CITY OF ALBUQUERQUE

**Planning Department
Transportation Development Services Section**

Re: Certification for Permanent Certificate of Occupancy (C.O.)
Albuquerque Memory Care Facility [D-19/D028]
8101 Palomas Ave.NE
Architect's Stamp Dated 12/23/11

**Re: Albuquerque Memory Care Facility, 8101 Palomas Ave NE, (D19/D028),
Request for Permanent Certificate of Occupancy - Approved
Approved Engineer's Stamp date: 1/20/11,
Certification dated: 12-22-11**

Grading and
Drainage Plan

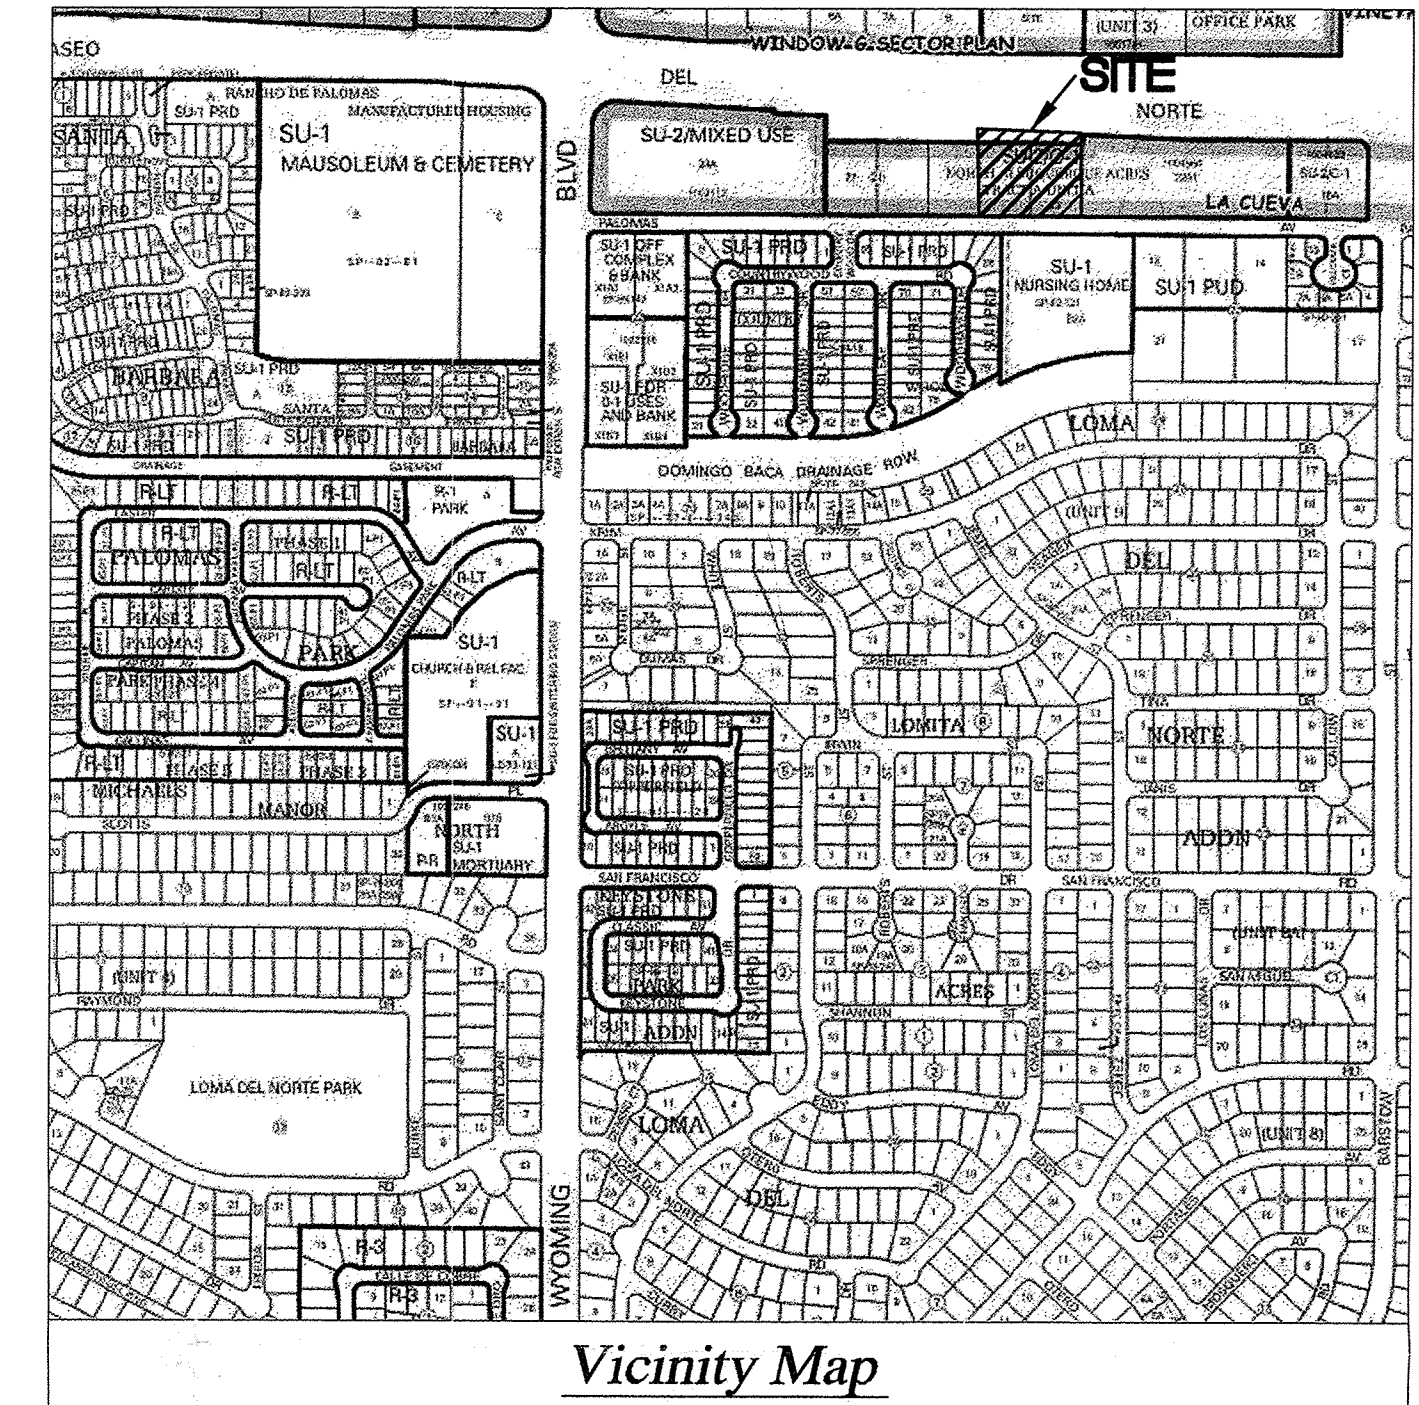
The water blocks at the drive entrances were not constructed as designed. Hydrology recommends building a "hump" north of the ADA access paths to function as a water block.
